CITY OF ALBUQUERQUE

August 3, 2021

Re: Hotel & Parking Structure
222 Central Ave SE
Request for Certificate of Occupancy
Transportation Development Final Inspection
Engineer's/Architect's Stamp dated 6-12-18 (K14D017)
Certification dated 7-26-21

1 SITE PLAN
TC1. SCALE: 1/16" = 1'-0"

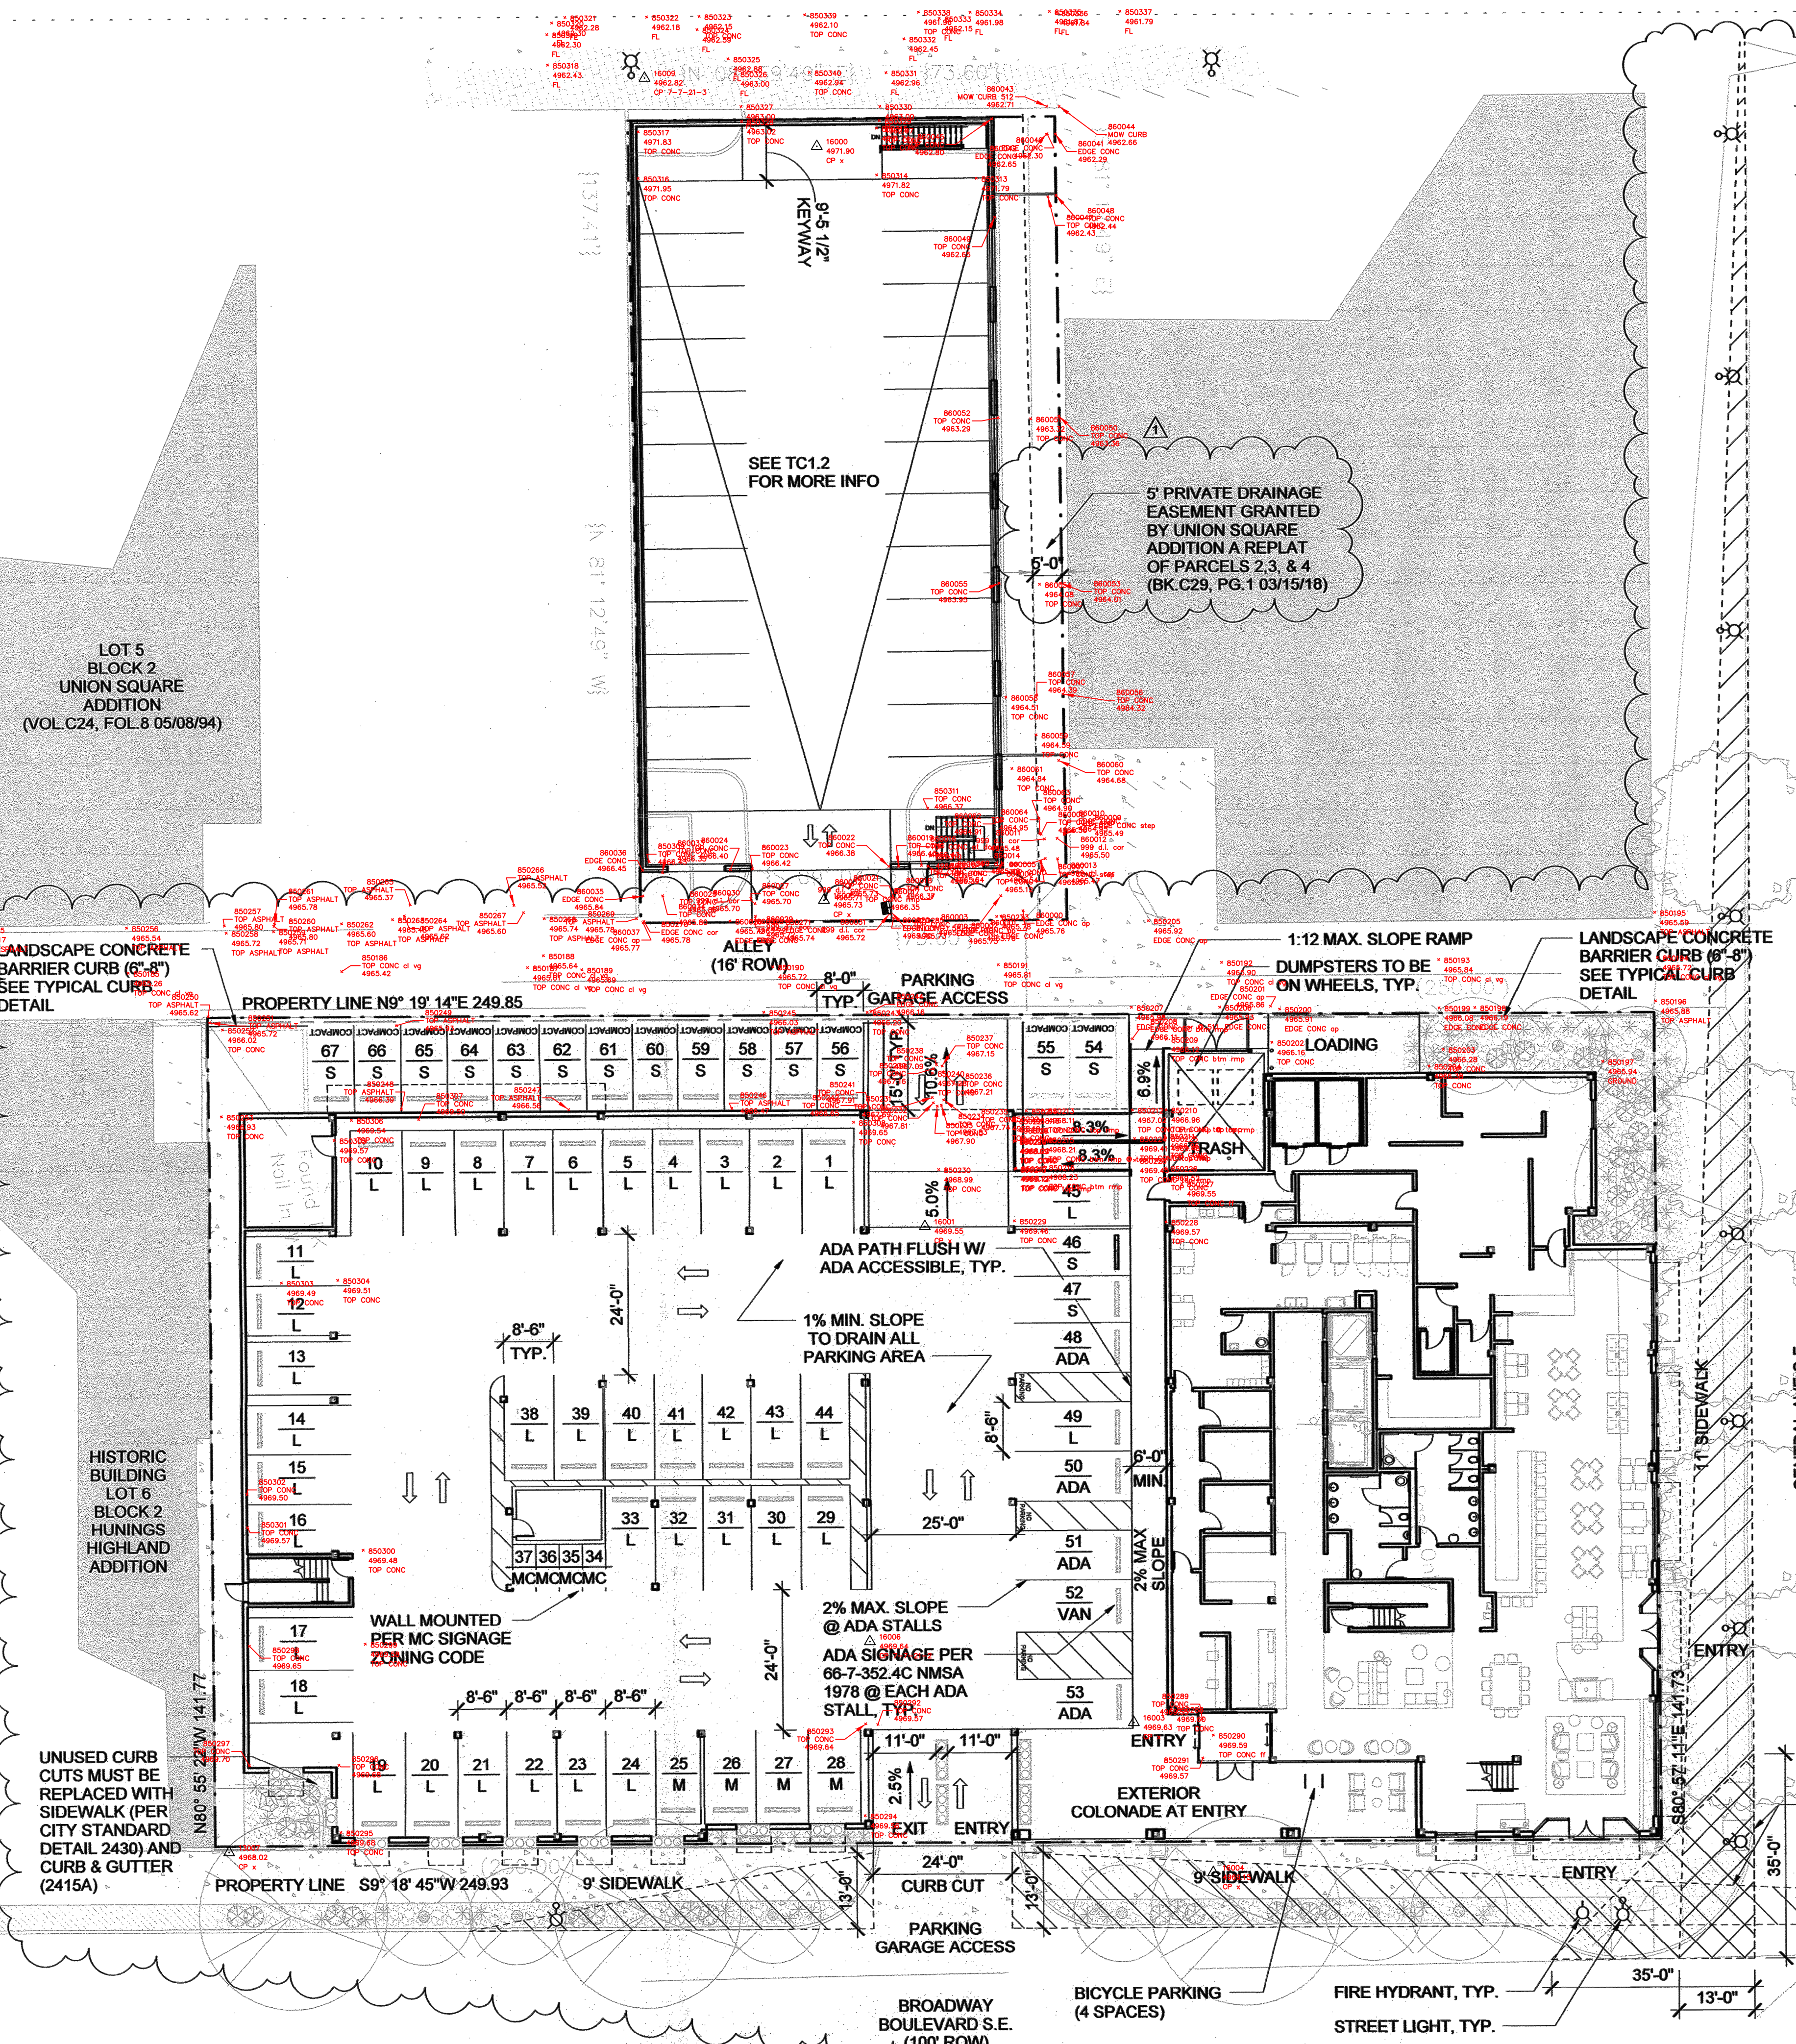
- An accepted and approved work order required for release of CO
- Please remove security fence, construction equipment and debris.
- Please complete brick paves and put up light pole.

1. The approved and stamped TCL with changes drawn in red.
2. Transportation Certification letter on either the plan or applicants letterhead.
3. A Drainage Transportation Information Sheet (DTIS)
4. Send an electronic copy of your submittal to PLNDRS@cabq.gov.
5. The \$75 re-submittal fee for log in and evaluation by Transportation.
